Application for Removal or Variation of a Condition following Grant of Planning Permission or Listed Building Consent

Demolition of existing shed and single storey rear extension. Proposed two storey extension, new dormer to the second floor and internal refurbishment to existing building (resubmission of 21/03768/FHA)

22/03372/FHA

Condition 2 to follow the updates of amended plans and elevations Revision D:

Project: 2040: Williams Wood, HP4 2RA  
 Title: Proposed Ground Floor Plan  
 Purpose: PLANNING Scale: 1:50@A1  
 Dwg No: 2040\_300 Revision: D

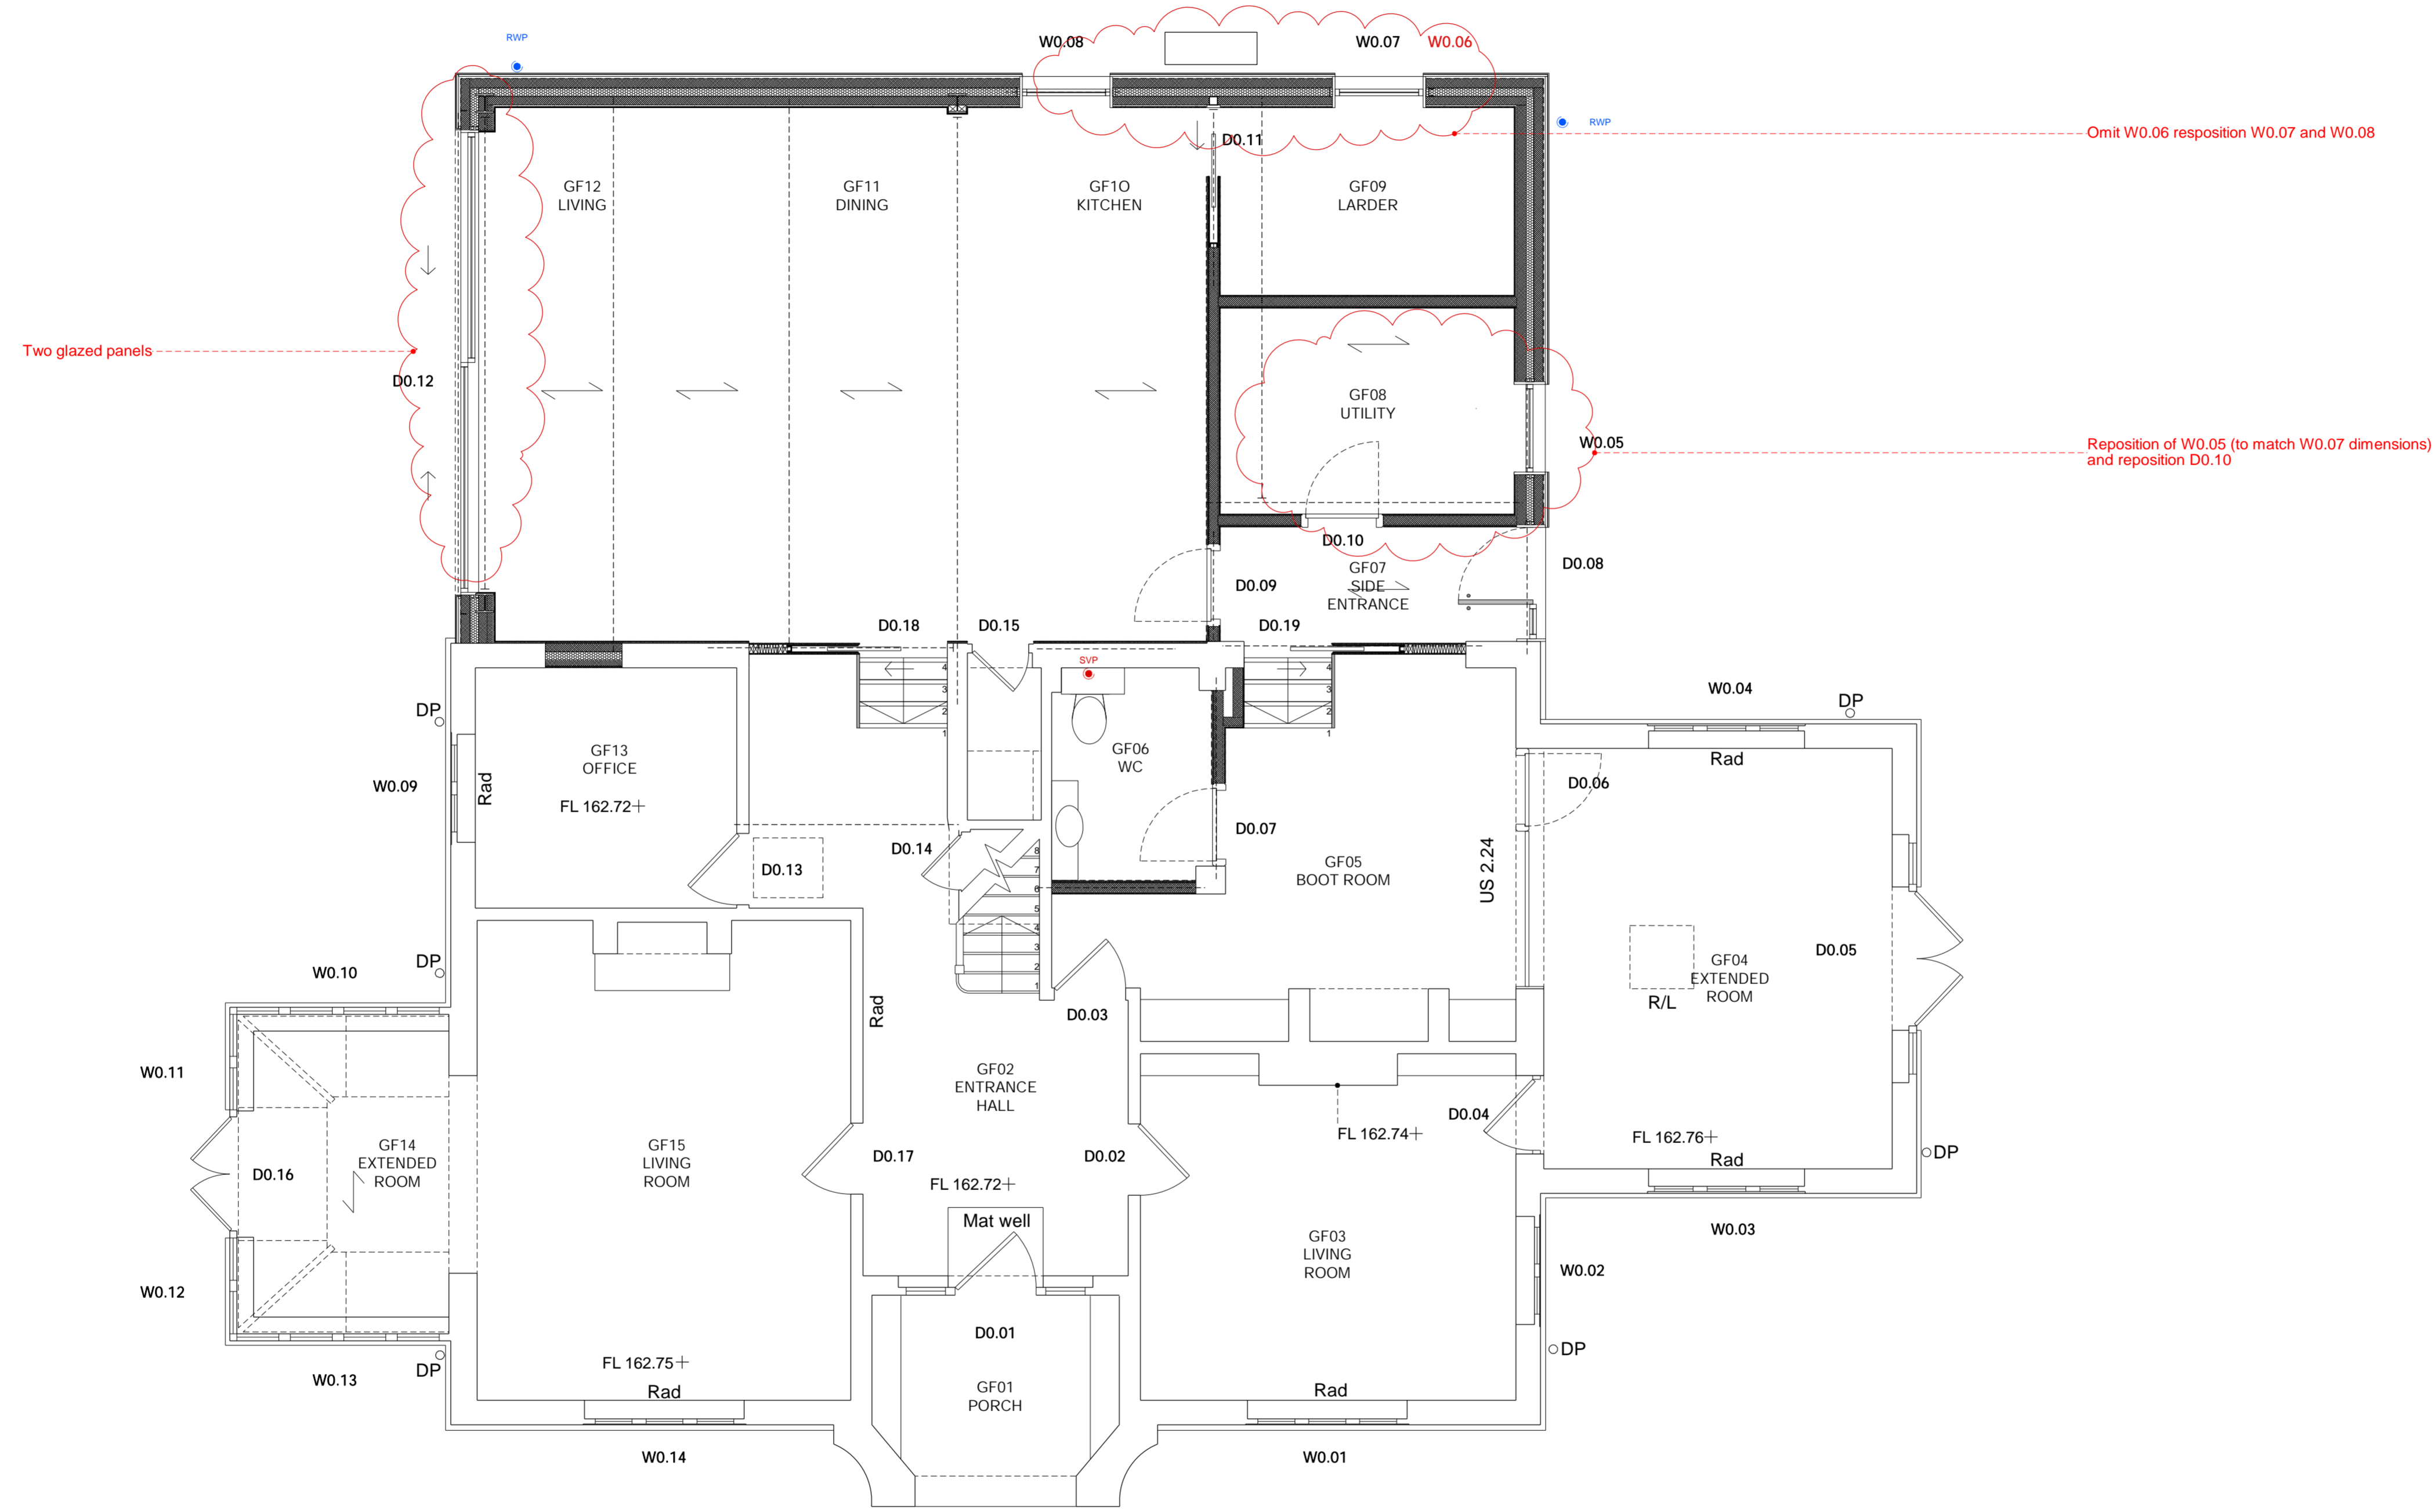
- Timber cladding for proposed two storey extension.
- Omit windows/glazing as shown on elevations and plans.
- Reposition windows/glazing as shown on elevations and plans.
- Rooflight size change and reposition as shown on plans.
- Centralise mullions to ground and first floor glazing North West of proposed extension.
- Shift North-West first floor terrace glazing towards glass balustrade by 300mm.
- Interior wall minor alterations.
- Retain existing openings on first floor as shown on proposed plans.
